10 December 2019

RE: METROPOLITAN COAL – REVIEW OF GEOTECHNICAL AND WATER ASPECTS OF THE LONGWALLS 305-307 EXTRACTION PLAN

METROPOLITAN COAL
Longwalls 305-307 Geological Structures
Identified at Seam Level

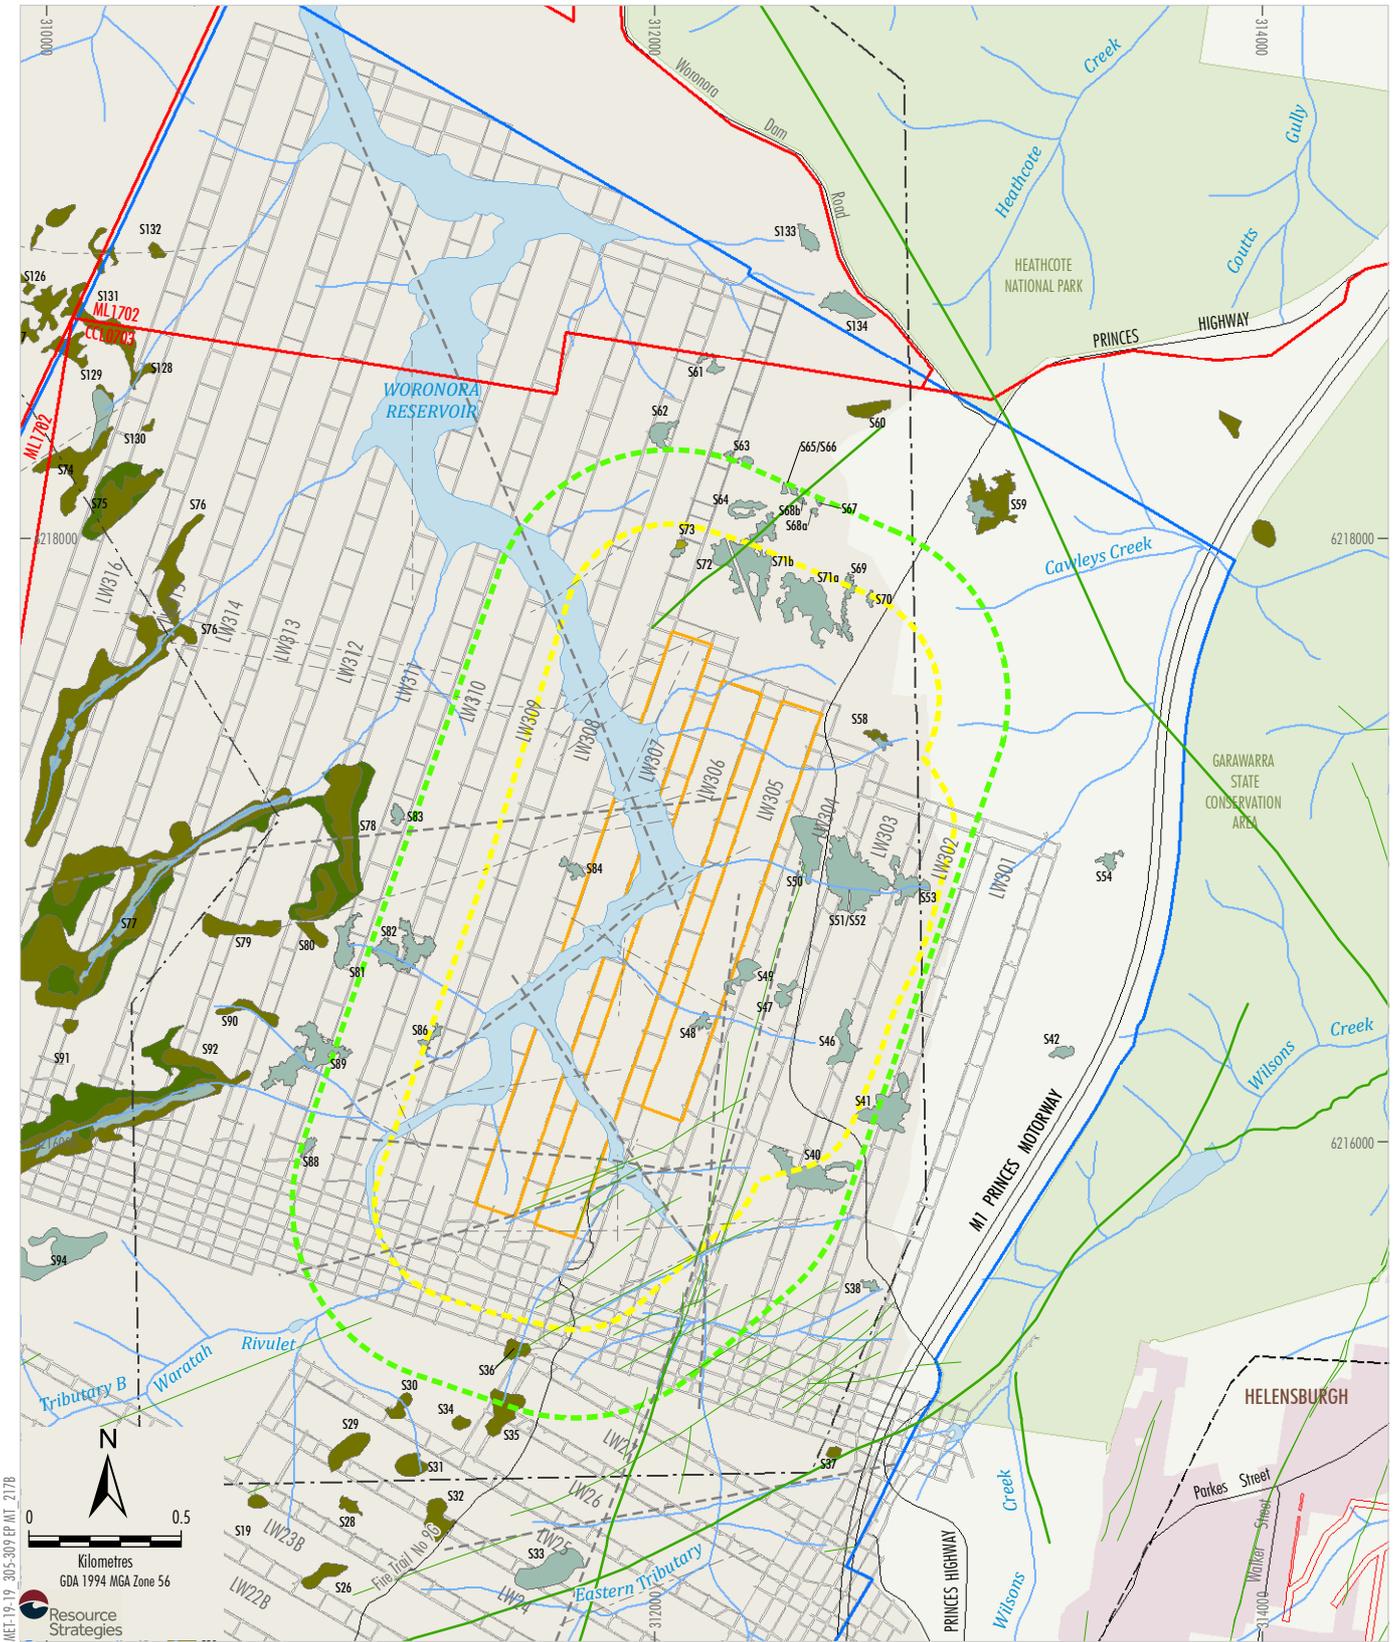
One final comment in relation to geotechnical/subsidence monitoring relates to subsidence impacts caused by fault structures. Figure 4 of the Longwall 305 – 307 Extraction Plan – Main Text showed a number of faults detected in the region of LW305 and LW306 (and also impacting the current LW304). The LW305 – 307 Extraction Plan - Subsidence Report (Section 1.5) discusses these faults but makes no further comment on their impact on either subsidence predictions or current subsidence behavior detected by monitoring results.

It is understood that such impacts are expected to be minor, but it would be useful if MSEC could provide a brief commentary on the experience during the mining of LW304 with respect to the fault that runs the length of the panel (F-0008), as to whether any impacts or anomalous behaviour has been detected. It would also be useful to comment on whether the future predictions have made any provisions for such anomalous behavior above LW305 and LW306 – if such behaviour has been detected.

In relation to subsidence monitoring, it would be valuable to focus some additional monitoring attention on points on either side of the fault region, where fault F-0027 crosses the base of the Woronora Reservoir beneath LW305, in order to gain a better understanding of the mining-induced impacts on such structures, particularly where they cross a valley floor.
